CITY OF ALBUQUERQUE

August 8, 2022

**RE: Horizon Auto Glass & Tint
8310 San Pedro Dr. NE
Permanent C.O. – Not Accepted
Temporary C.O. - Accepted
Engineer's Certification Date: 07/25/22
Engineer's Stamp Date: 02/22/21
Hydrology File: C18D107**

Hydrology
Report

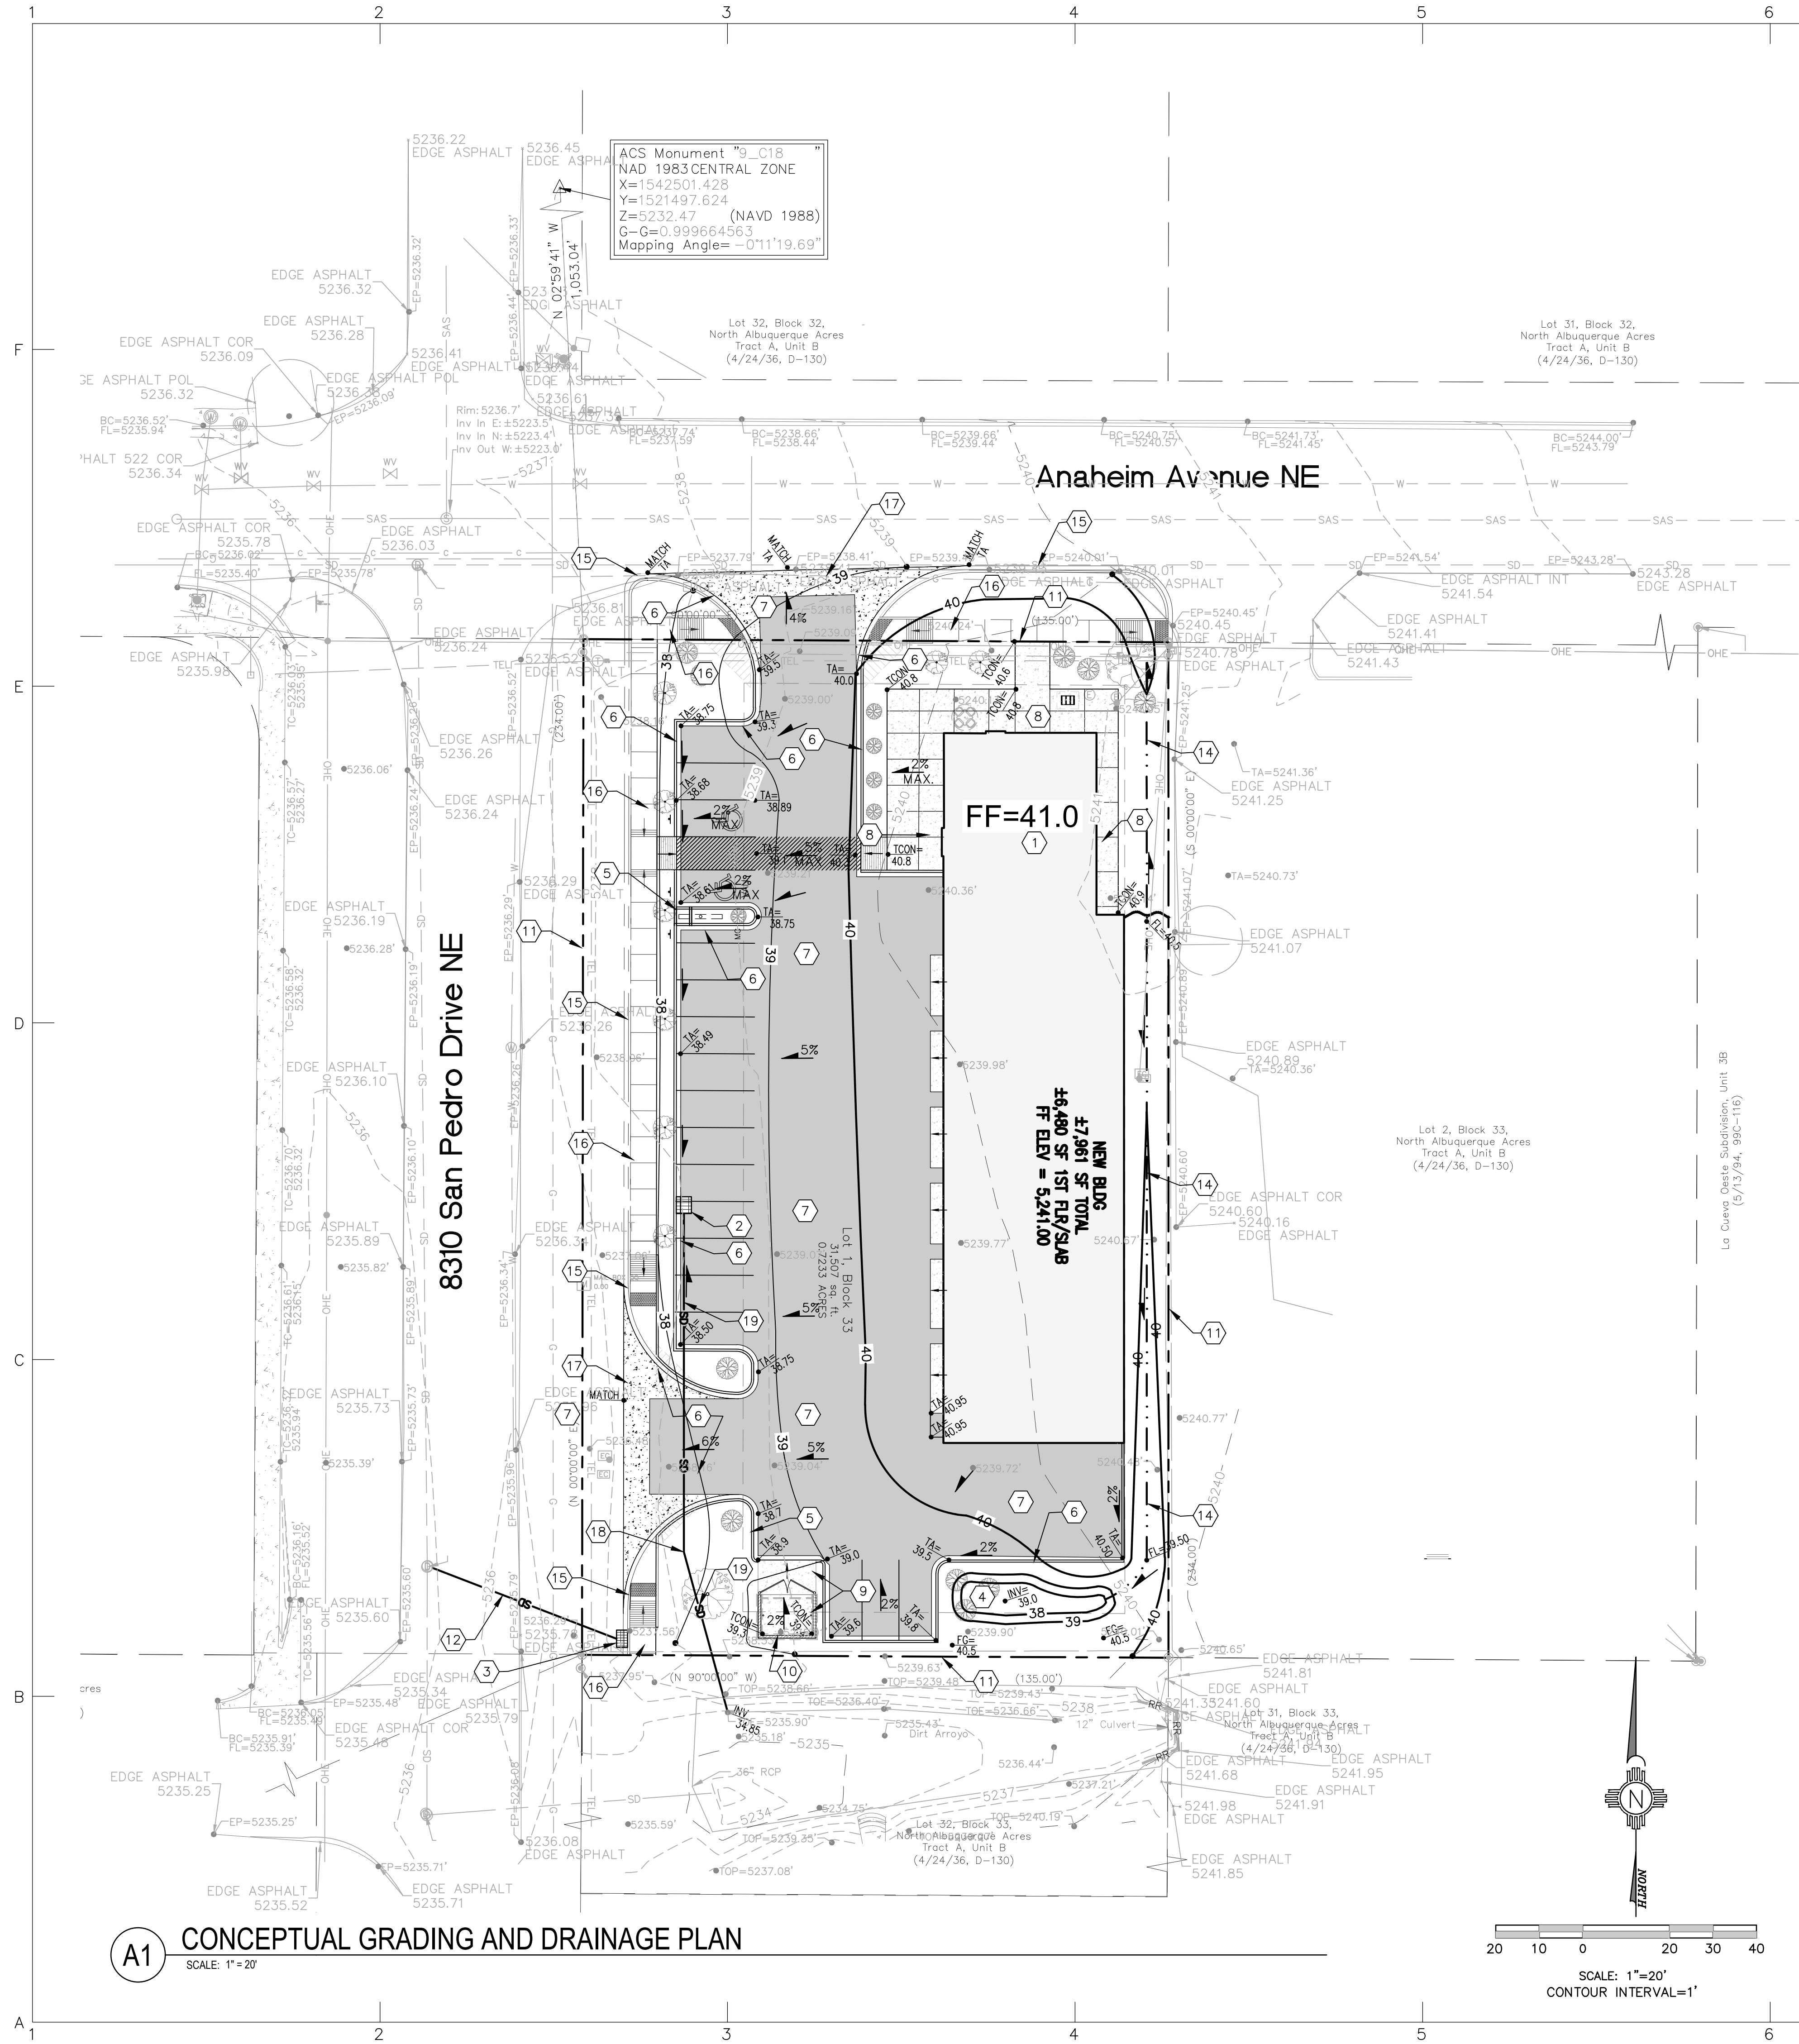
1. Please provide the as-built volumes of Pond 1 & Pond 2. Then please red line out as shown below and add the text showing the as-built volumes provided.

~~VOLUME PROVIDED 0.0AF – 0.0 CF*~~
~~* OWNER W PAY FEE IN LIEU OF PONDING.~~
~~* \$8/CF* 823.9 CF – \$6,591.20~~

VOLUME PROVIDED (PER AS-BUILT) =
POND 1 = XX CF
POND 2 = XX CF
TOTAL SWQ VOLUME = XX CF

Sheet Title:
Conceptual
Grading and
Drainage Plan

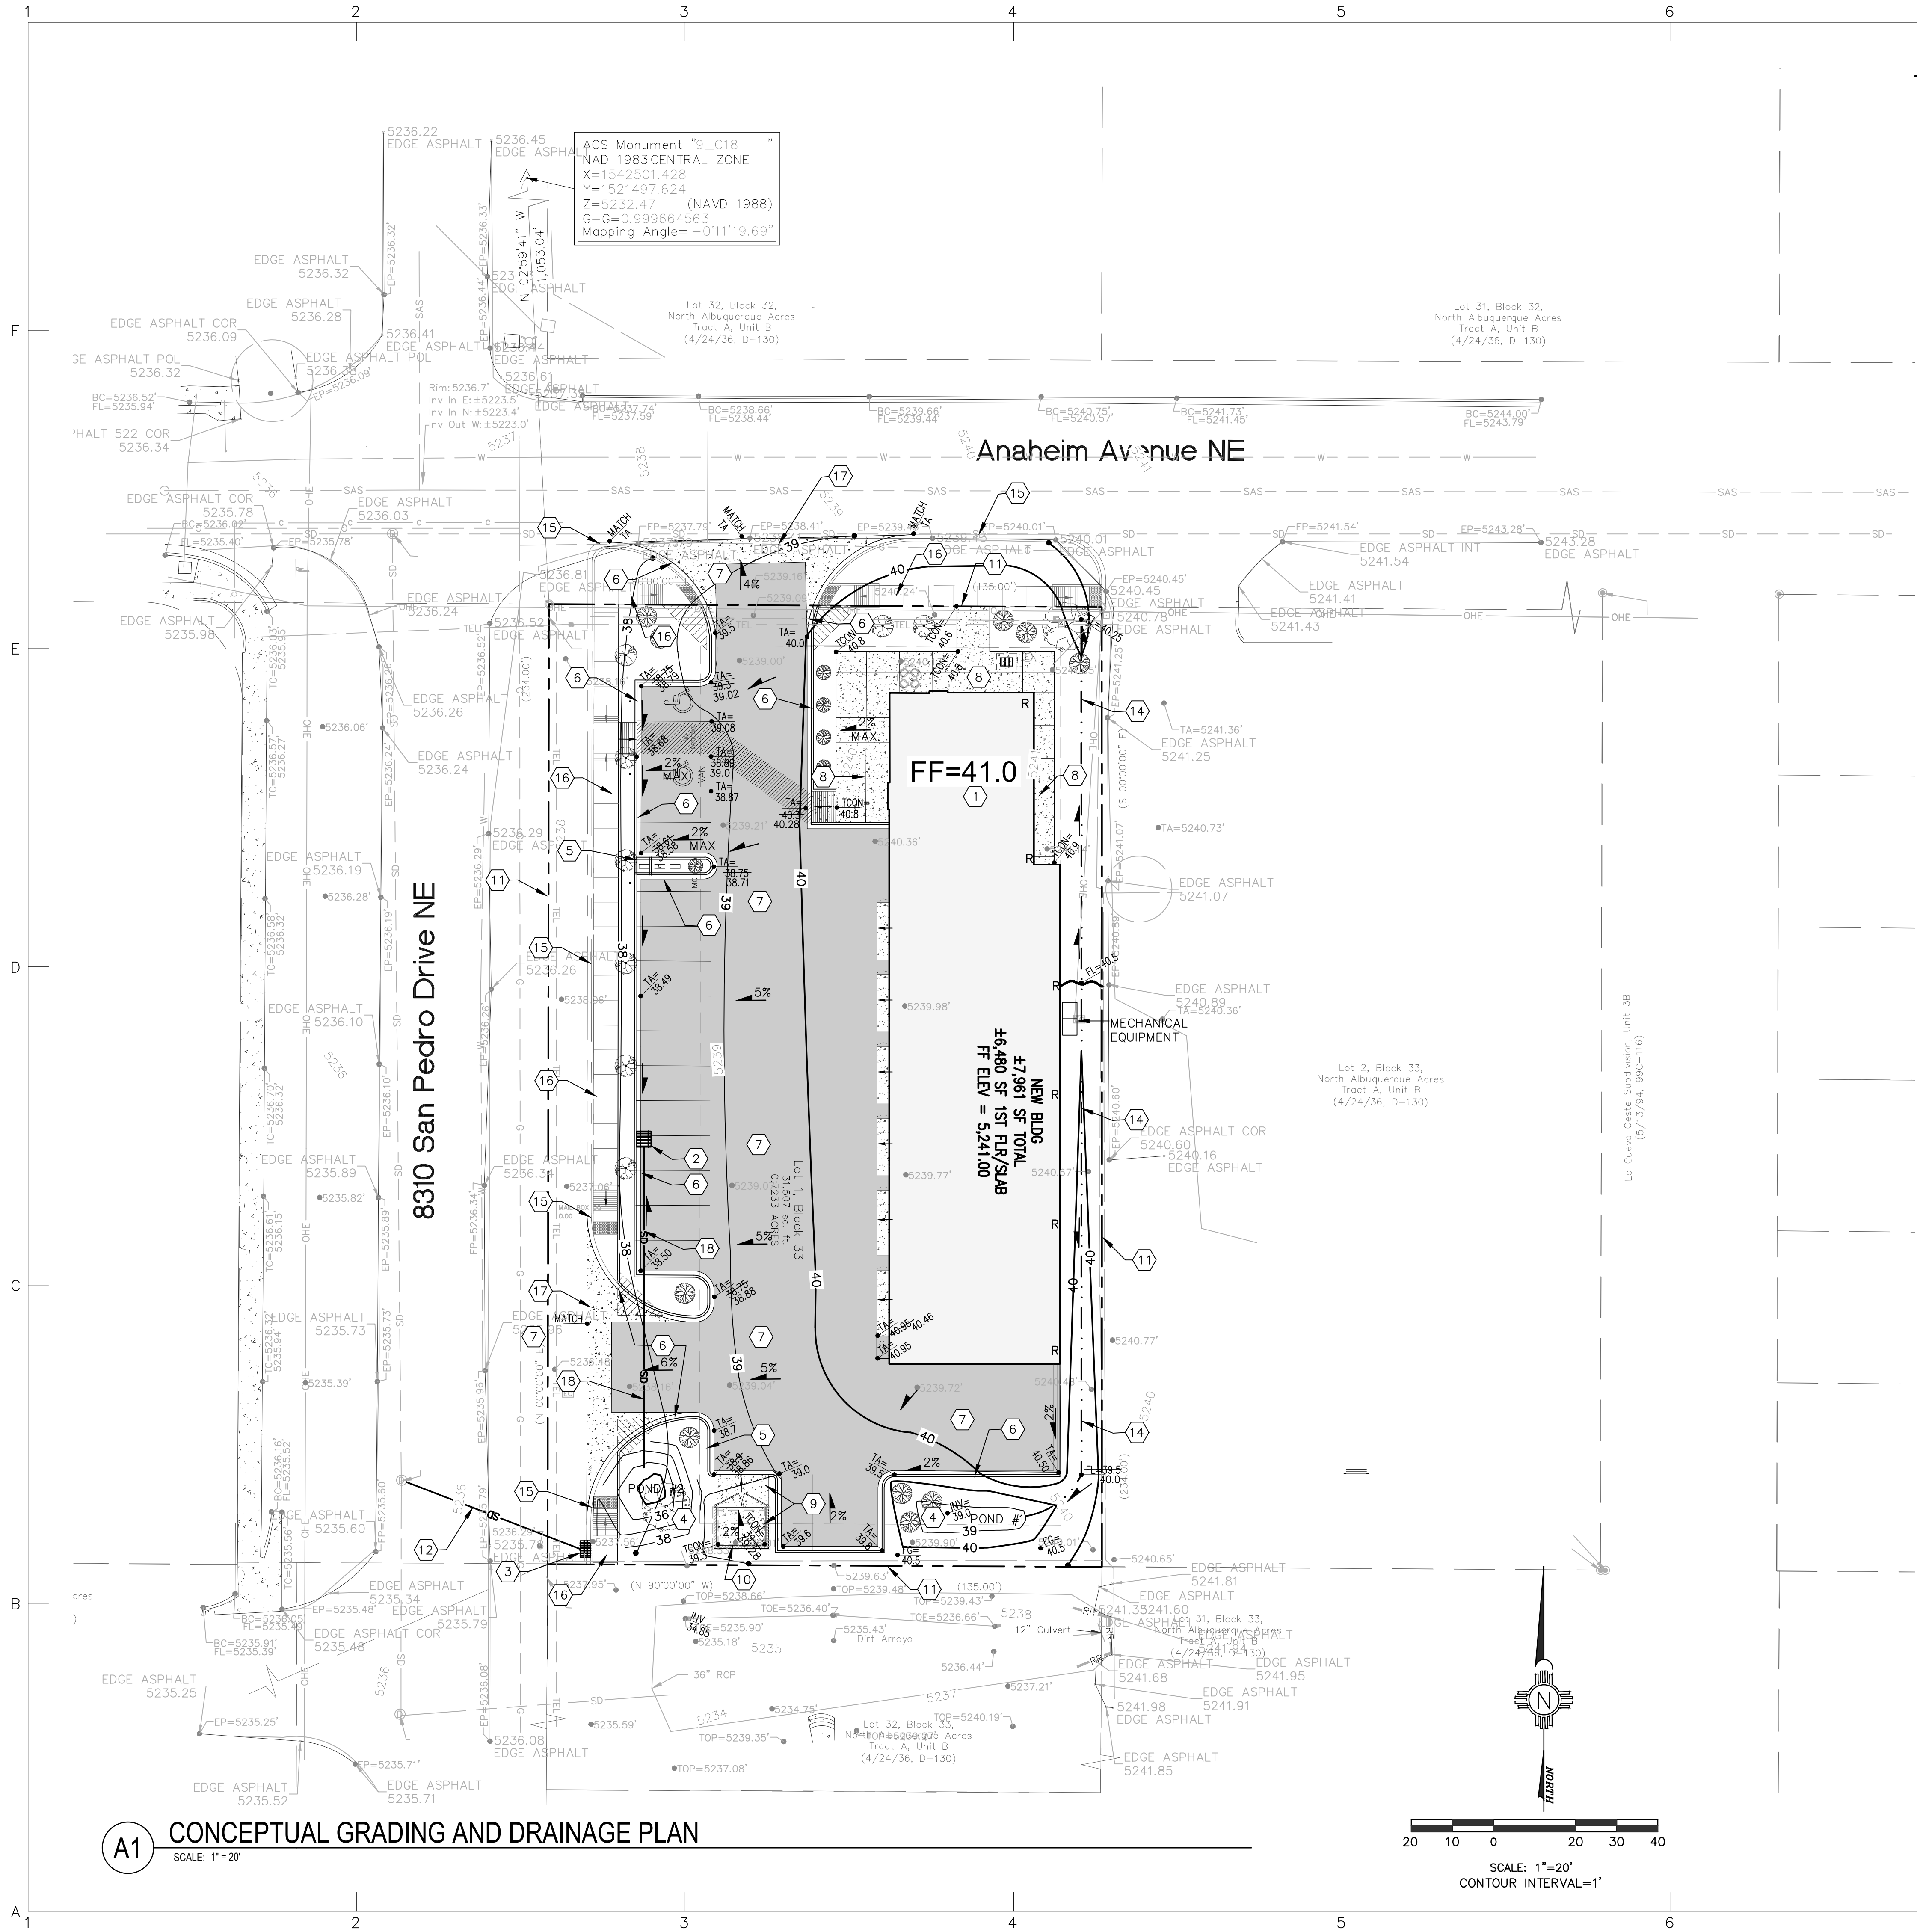
2. Please provide the Drainage Covenant with Exhibit A for the stormwater quality ponds per Article 6-15(C) of the DPM. Please submit the original copies along with the \$ 25.00 recording fee check made payable to Bernalillo County to Carrie Compton (cacompton@cabq.gov) on the 4th floor of Plaza de Sol.
